From: James Cross <James.Cross@arun.gov.uk>
Sent: 03 July 2020 10:33
To: Planning.Responses <Planning.Responses@arun.gov.uk>
Subject: FW: BN/46/20/PL - Land Rear of Poachers, Eastergate Lane, Chichester, West Sussex

Subject: RE: BN/46/20/PL - Land Rear of Poachers, Eastergate Lane, Chichester, West Sussex

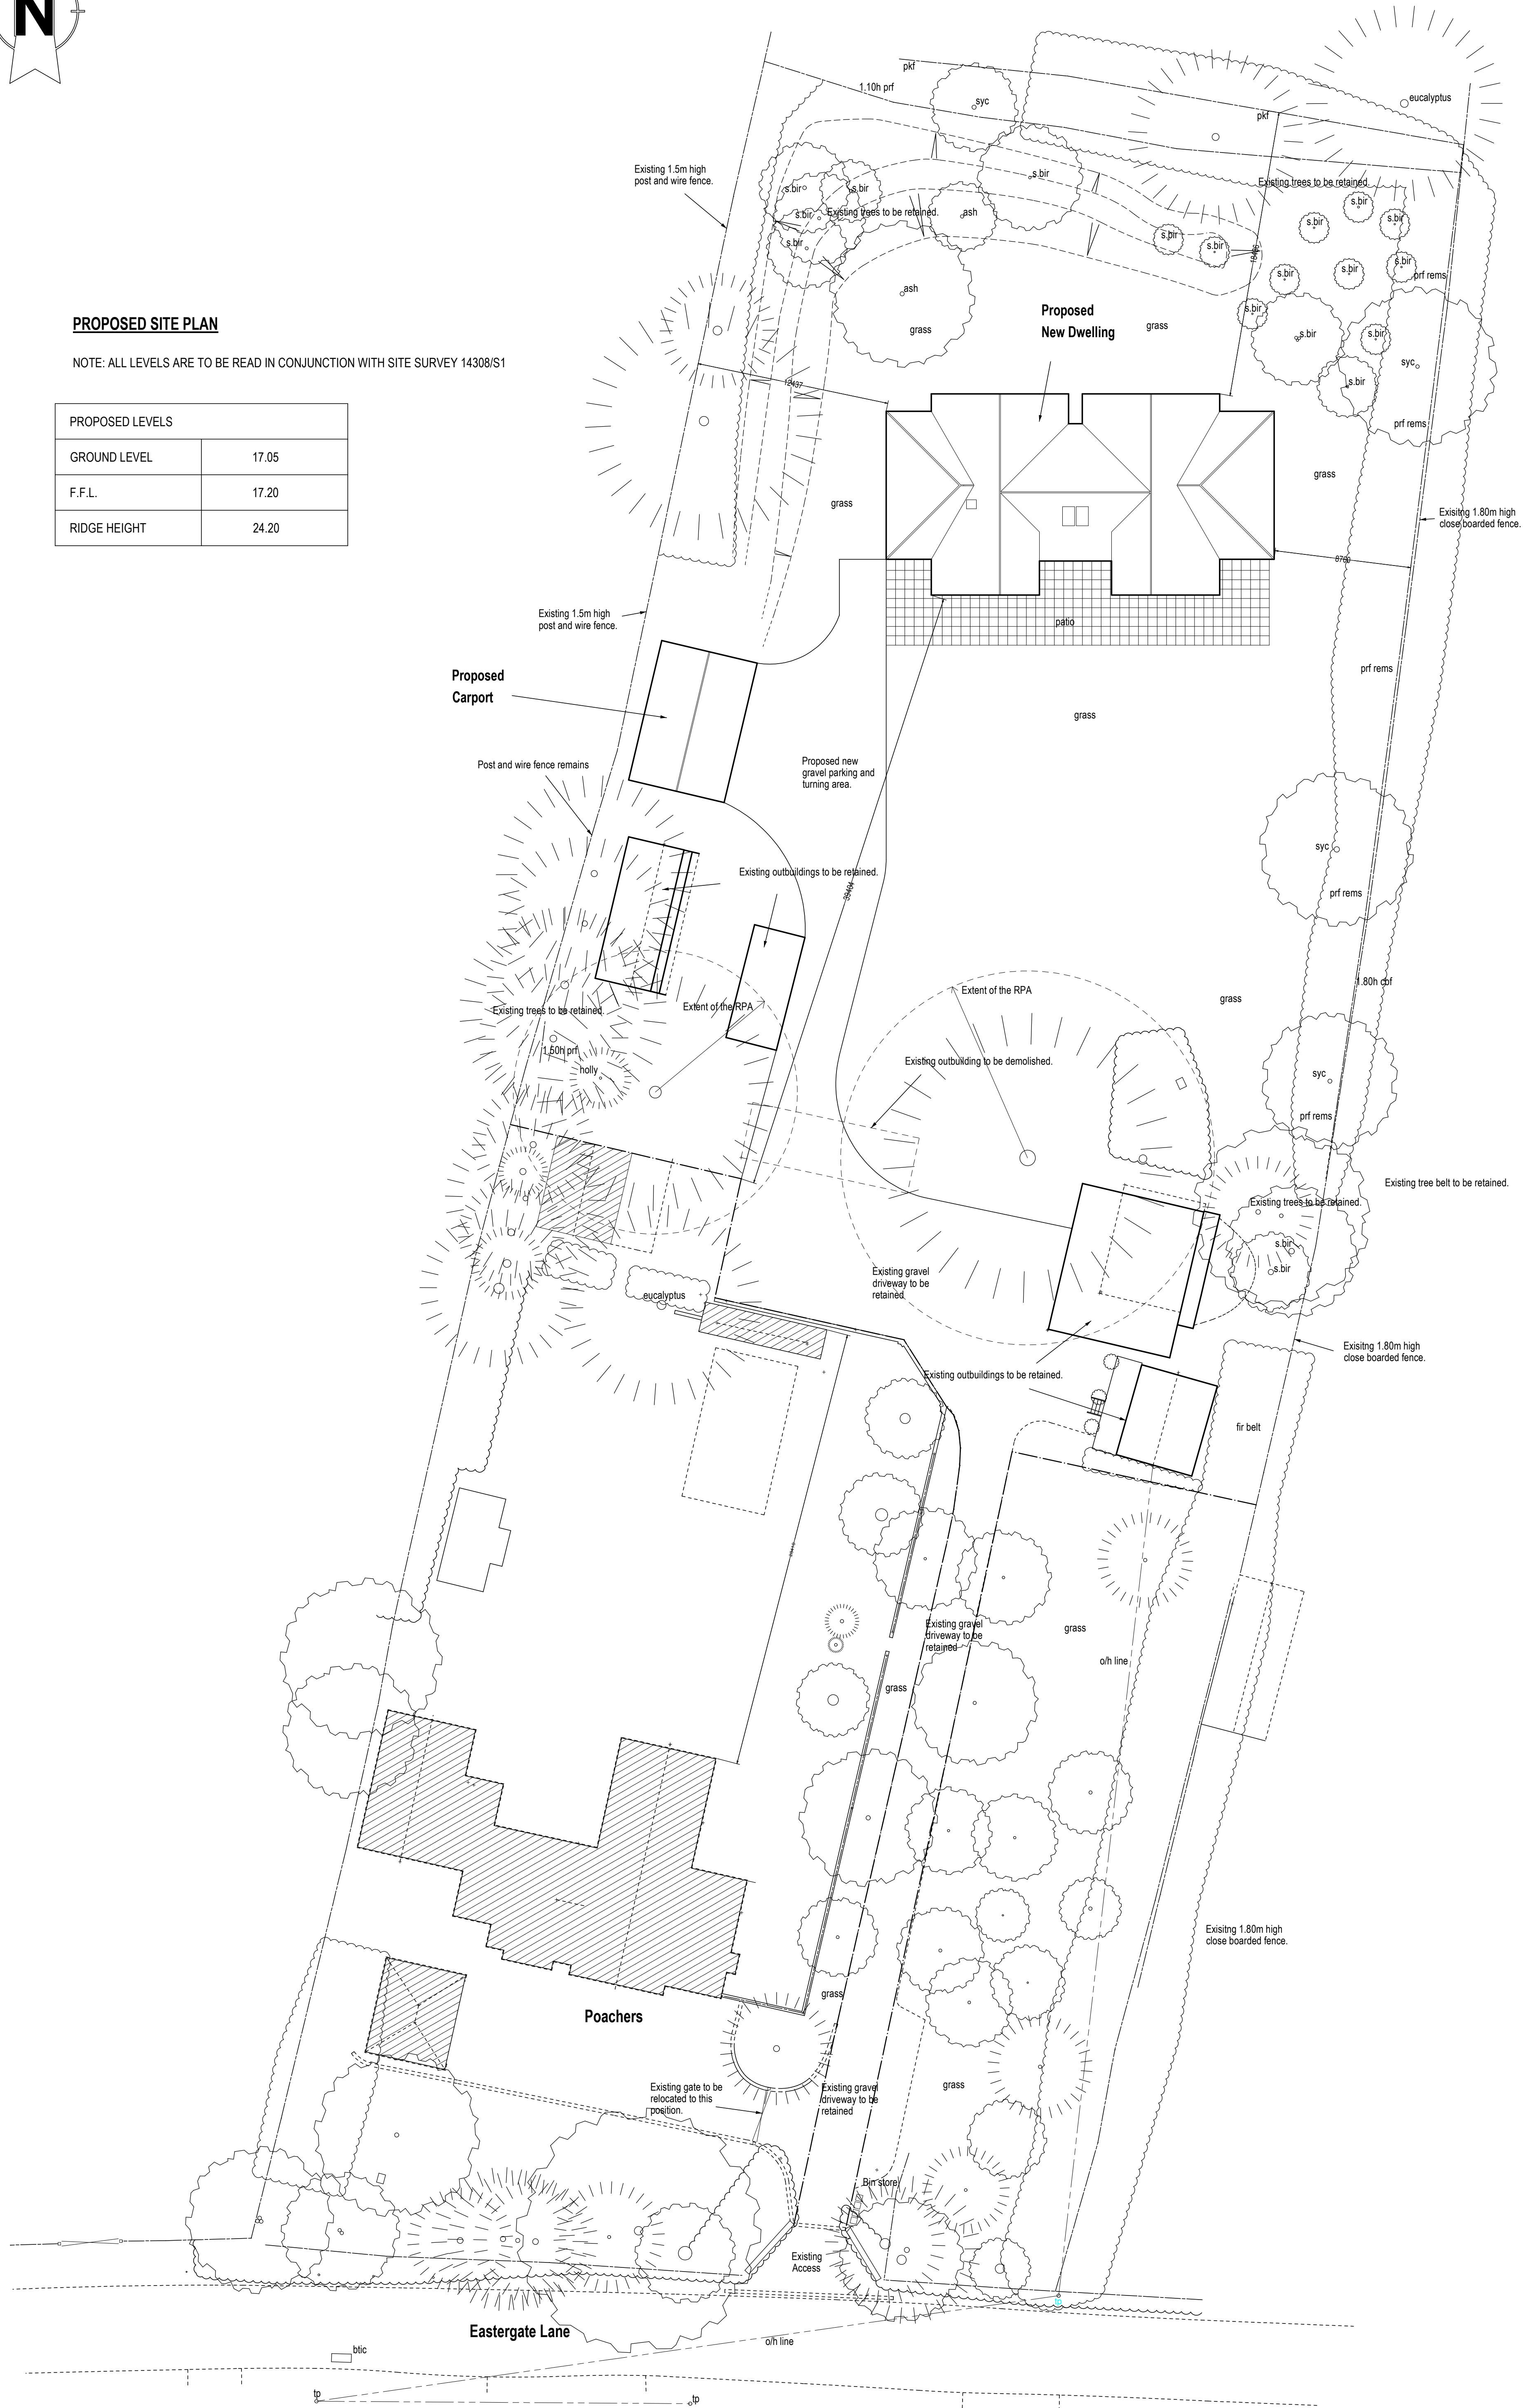
- 1) Amend the Site Plan to show fire truck tracking/turning area
- 2) Amend the Site Plan to show bin store labelled at the front of the site (I'm aware the capacities are there, it just needs labelling)
- 3) Could you submit a Phase 1 Habitat Survey? Please provide an extended Phase 1 if one is available
- 4) Please provide a Drainage Impact Assessment to address how connections to Lidsey Waste Water Treatments Works would be accommodated

- 1) Amend the Site Plan to show fire truck tracking/turning area
- 2) A Preliminary Ecology Assessment has been prepared and is attached.
- 3) A drainage layout has been provided showing that the new dwelling will not be connecting to the main sewer and as such there will be no impact to Lidsey Waste Water Treatments Works.

As discussed, the site plan already shows a bin store.
